Solid Waste Services Rezoning Petition Notes

February 2012 Rezoning Packet

2008-039 Charlotte Mecklenburg Historic Landmarks Commission

**RZ1.0**

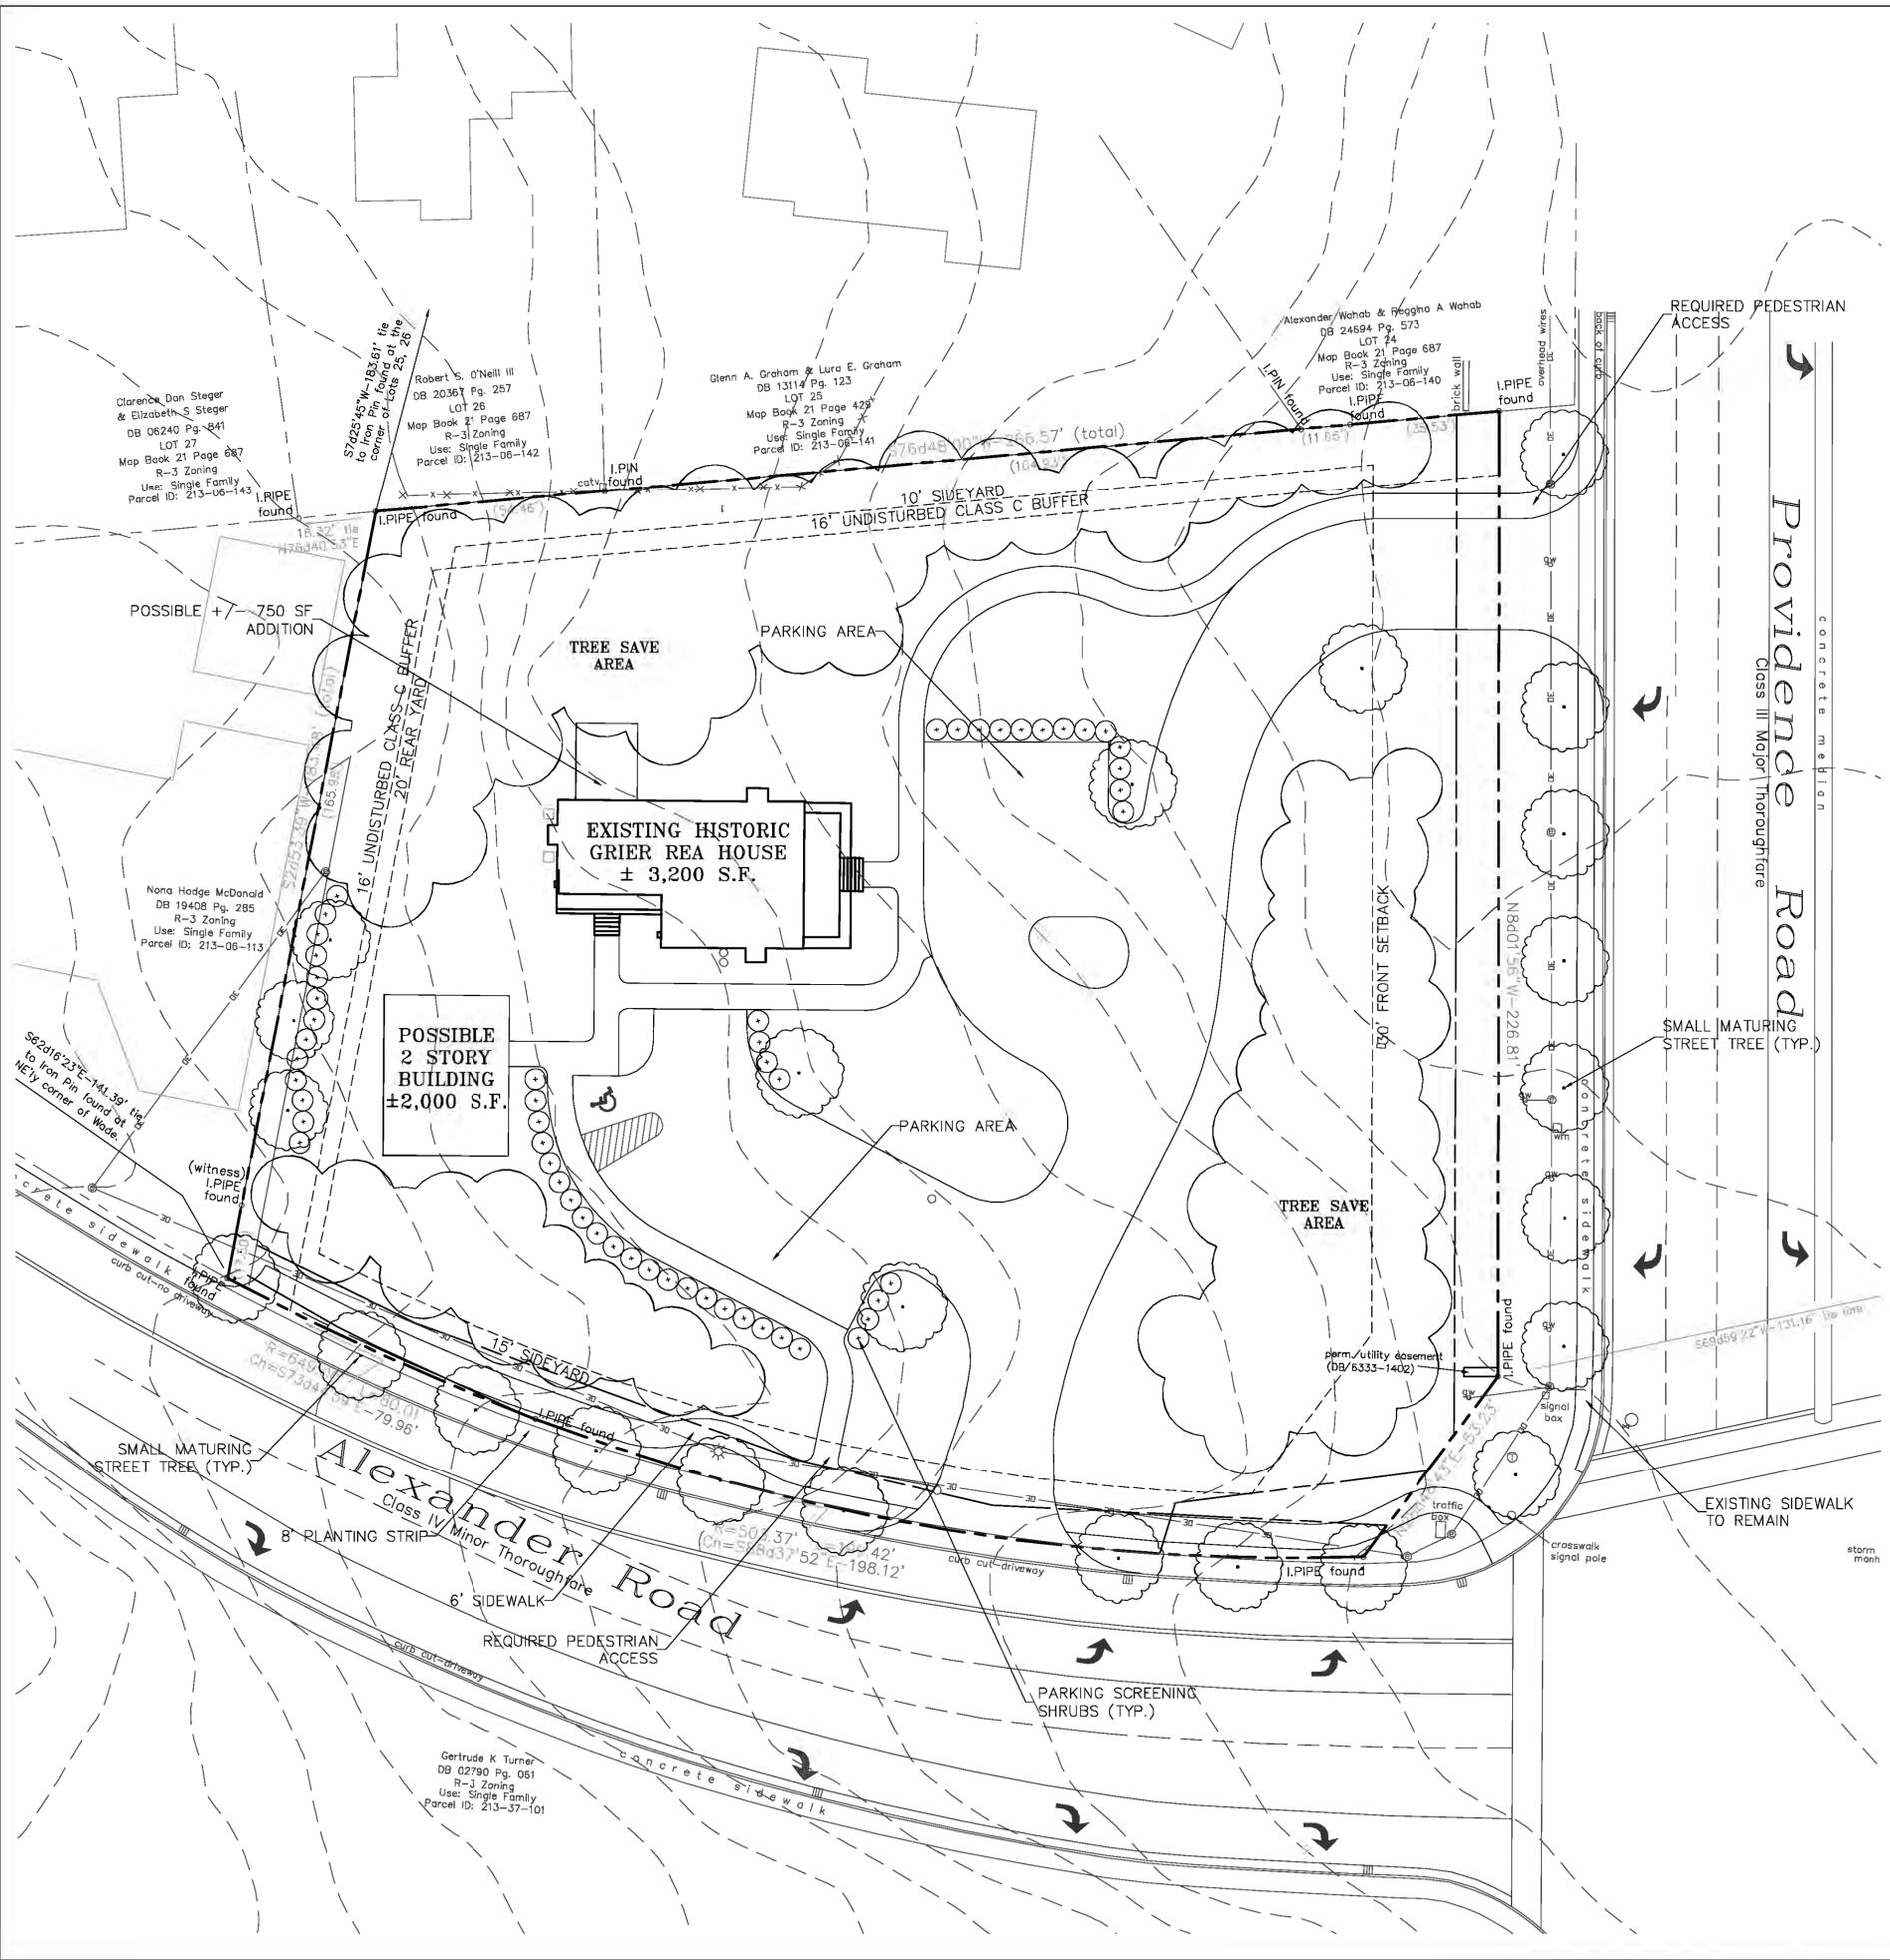
Site plan is missing the necessary Solid Waste notes for multifamily usage. Plans must specify garbage container type (dumpster, compactor), recycling space allowed, or if site proposes use of a private hauler.
